NSW Department of Climate Change, Energy, the Environment and Water

Subject: MidCoast Regional Organics Facility (SSD-84090218) – Environmental Impact Statement

Detailed advice to DPHI Planning & Assessment regarding the MidCoast Regional Organics Facility (SSD-84090218) – EIS

BULK EARTHWORKS PLAN
1:500

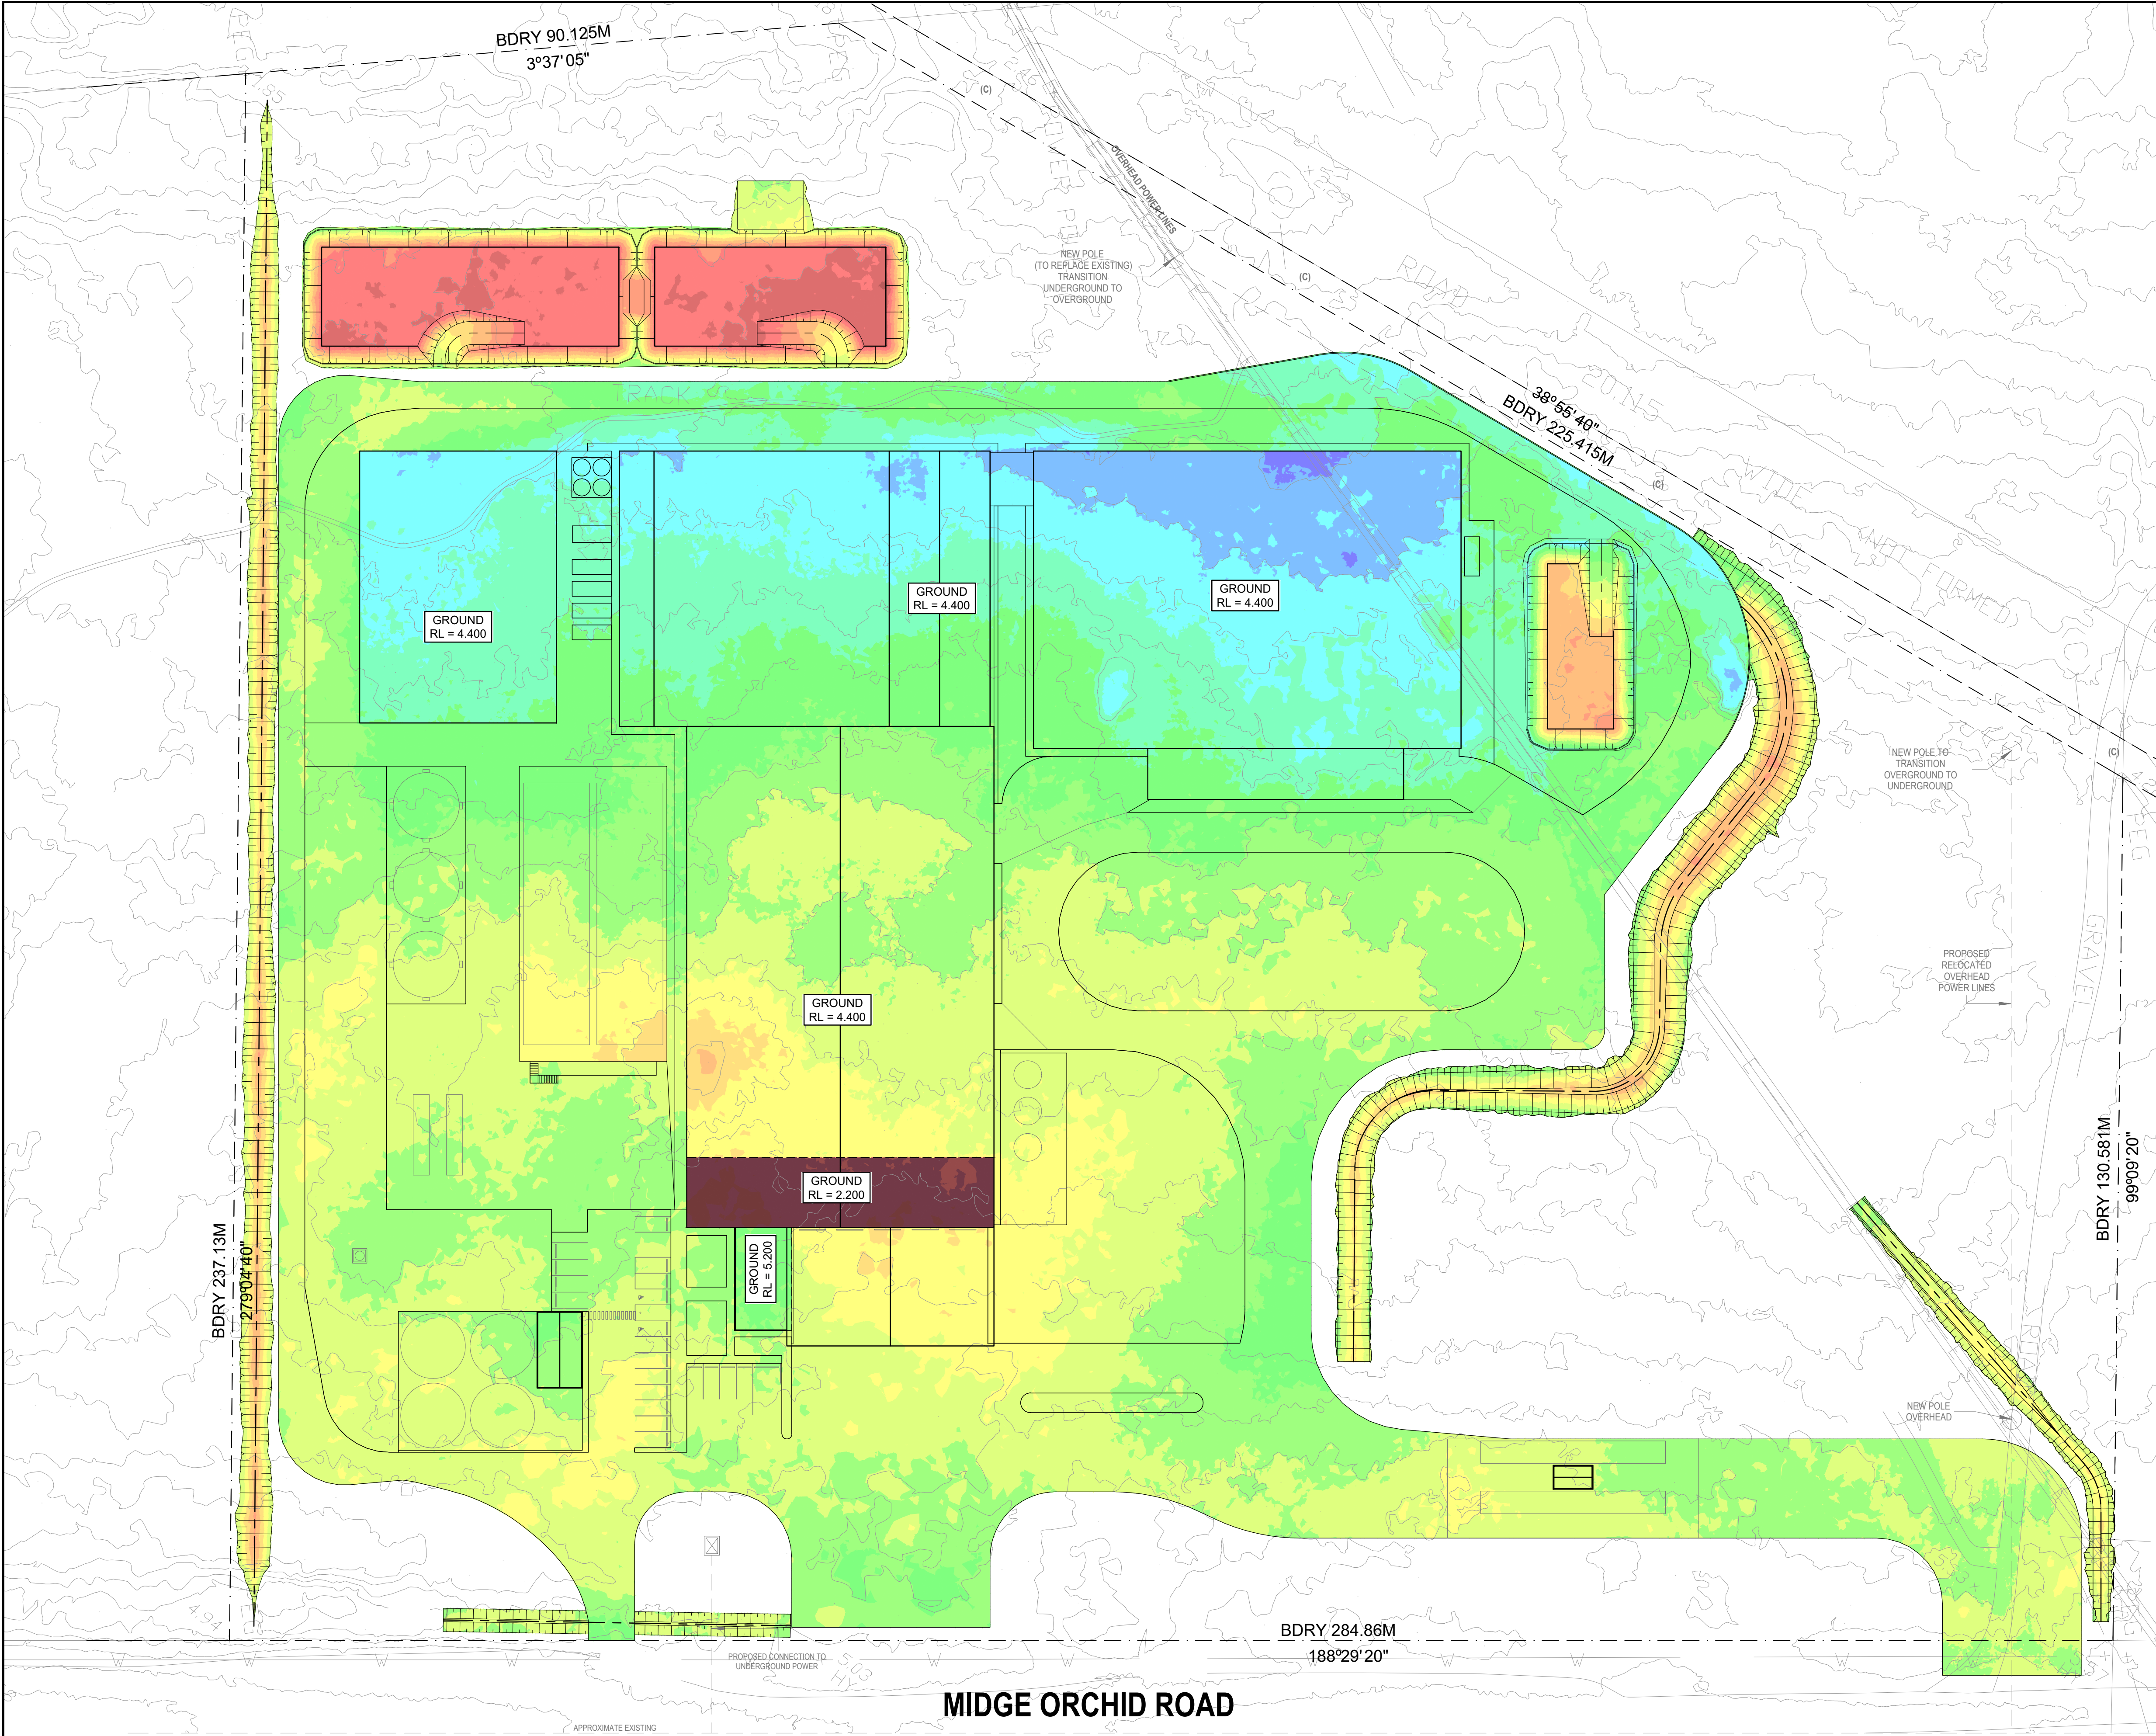
Insufficient information has been provided to confirm the potential for groundwater interception and take due to the project. Based on the cut and fill diagrams and descriptions of groundwater depth there is the potential for groundwater interception, however this has not been stated. Further clarification and assessment of inflow volumes if relevant is therefore required. Please see the following links for guidance: [Groundwater assessment toolbox for SSD/SSI](#) and [Minimum requirements for building site groundwater investigations and reporting](#).

- Clarify the potential for aquifer interception due to the project.
- Where take is required, quantify the maximum annual volume of water take due to aquifer interference activities during construction and operation.
- Demonstrate the ability to obtain sufficient entitlement unless an exemption applies.
